Uisce Éireann Water Supply Project Eastern and Midlands Region

**Supplementary Response to
Submission Report**

2 Response to South Dublin County Council

Drawing file: Chapter 04 Proposed Project Description / Figure-4.97-Termination-Point-Reservoir-Proposed-Landscape-Plan.pdf

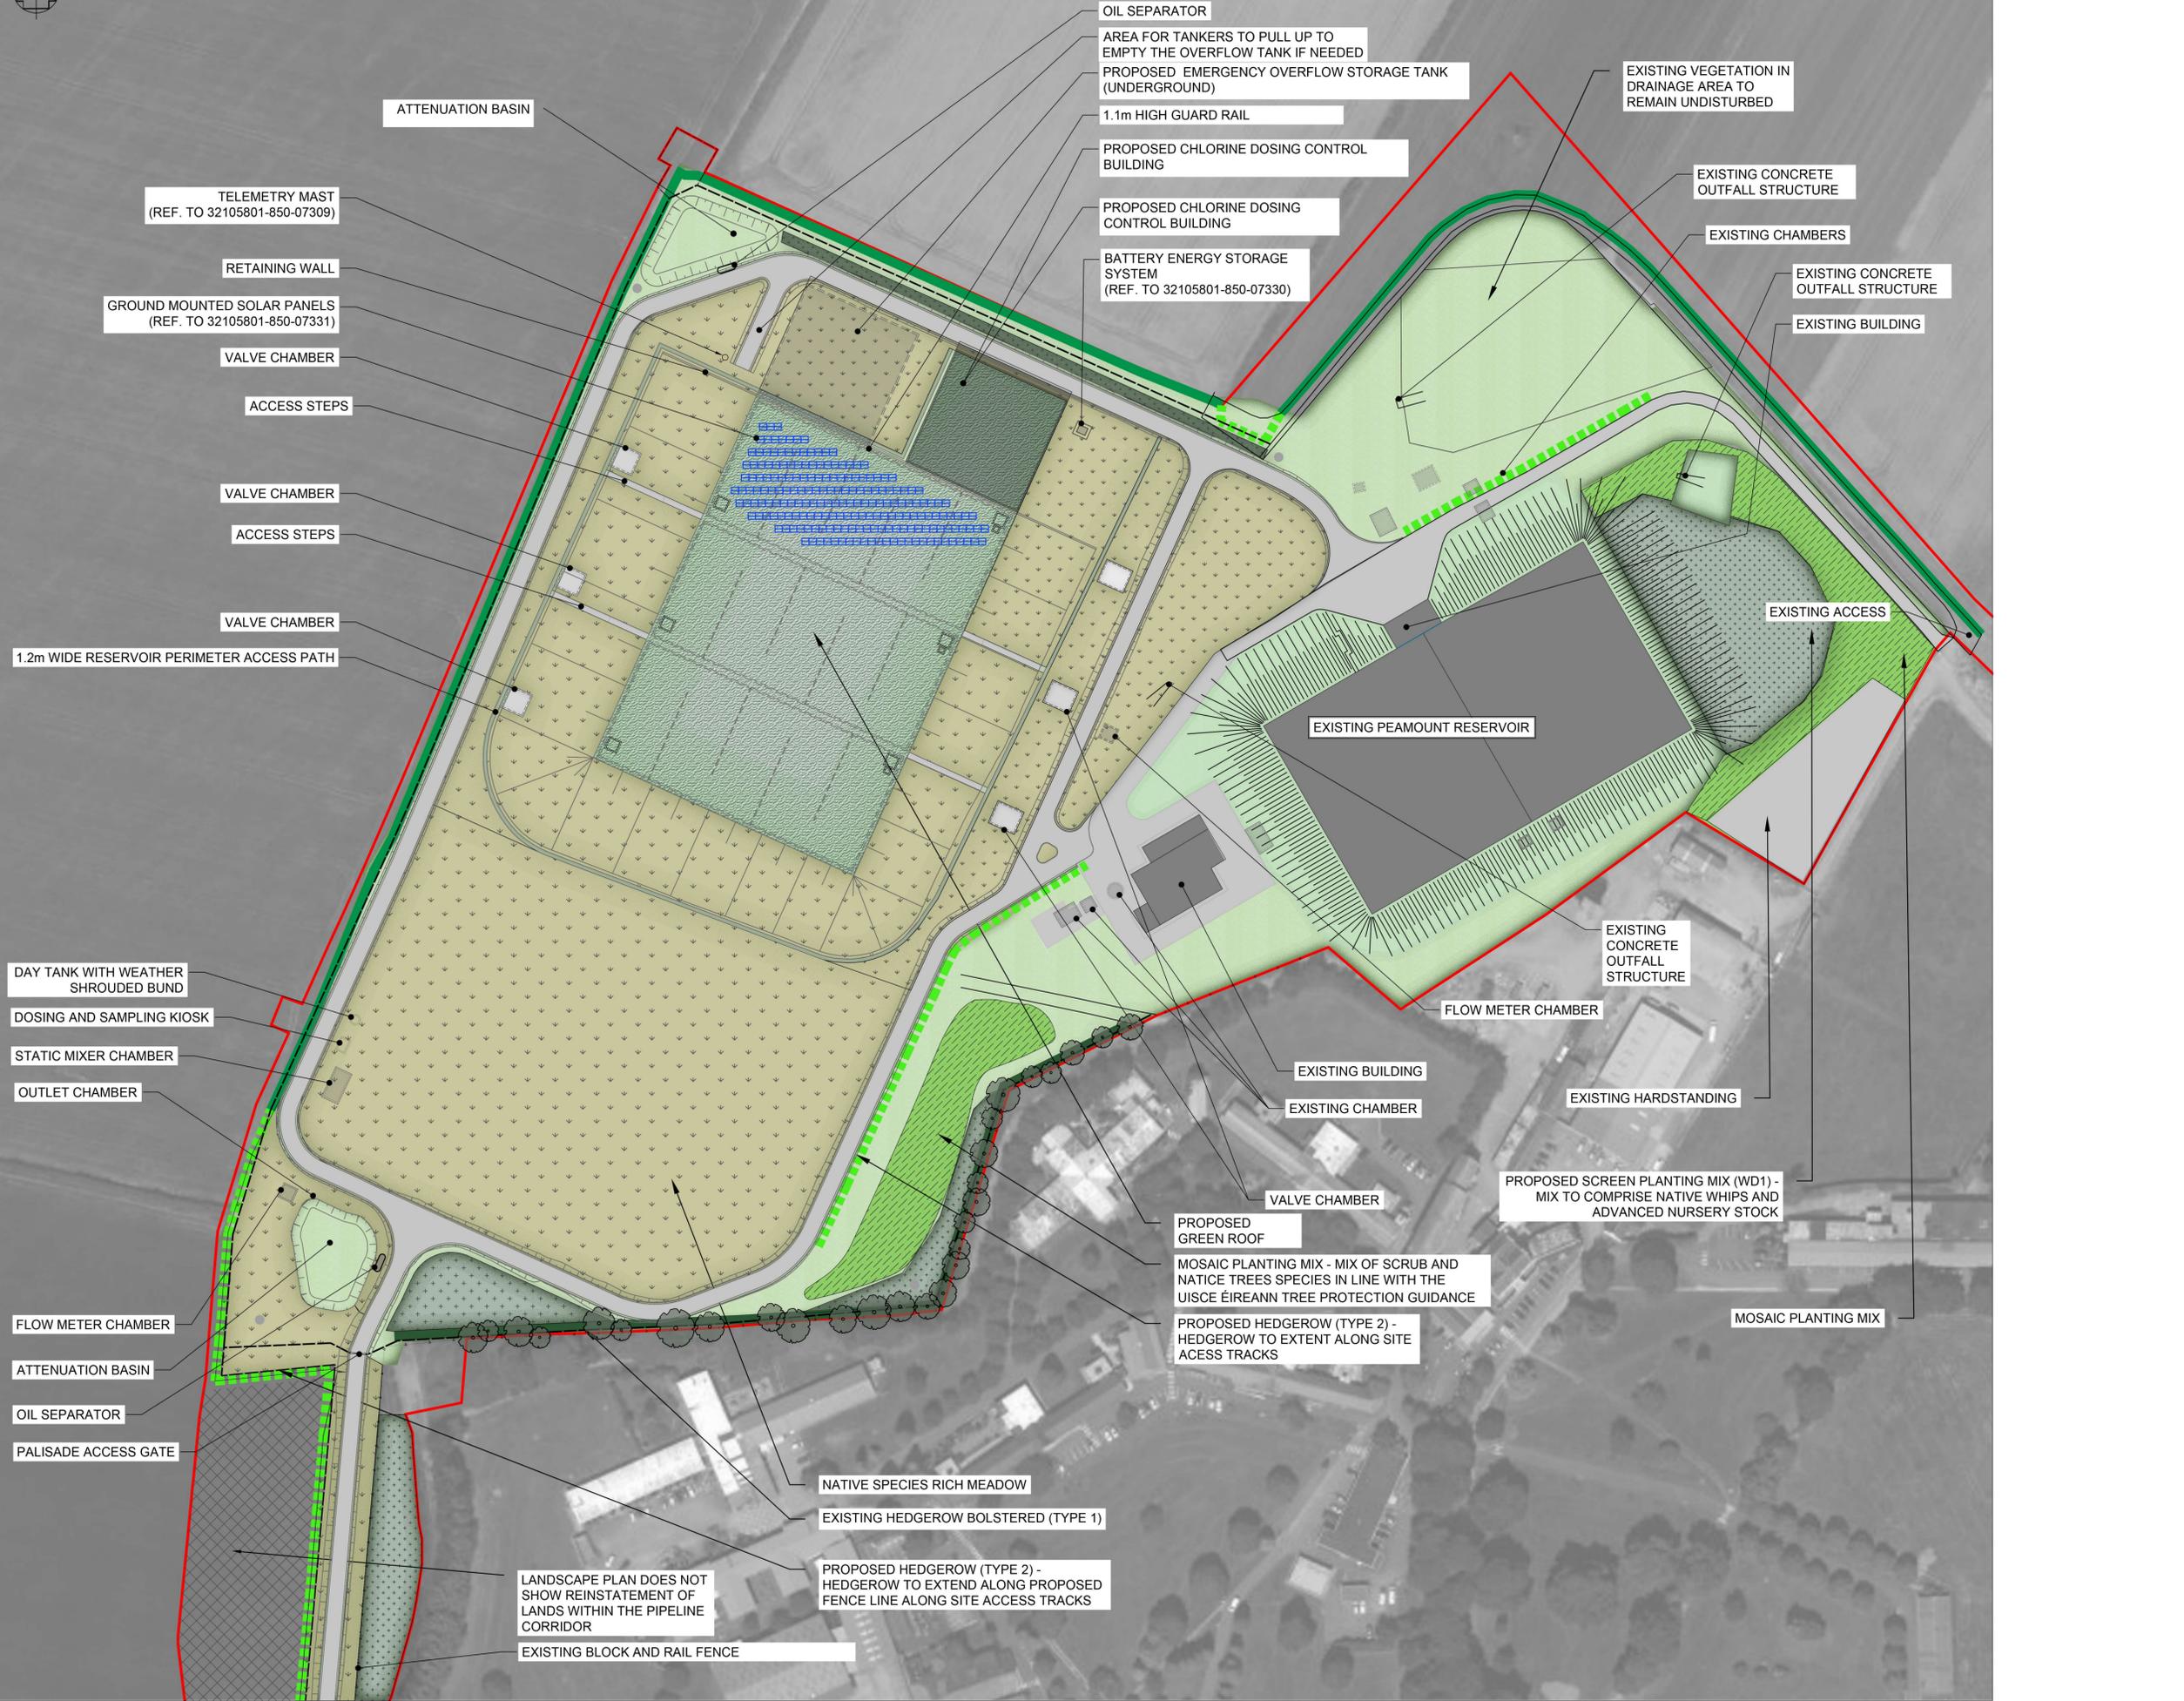
- The Applicant/developer shall make visibility splay of 2.0m x 45m in both directions from the entrance. Sightlines should be to the near side edge of the road to the right-hand side of entrance and to the centreline of the road to the left-hand side of the entrance (when exiting); and

- As shown in EIAR Figure 4.71, the visibility splay has been provided at the TPR entrance exceeding the minimum visibility splay of 2.0m x 45m, has been provided in both directions from the entrance. In order to allow for overtaking, sightlines have been shown to the near side edge of the road in both directions; and
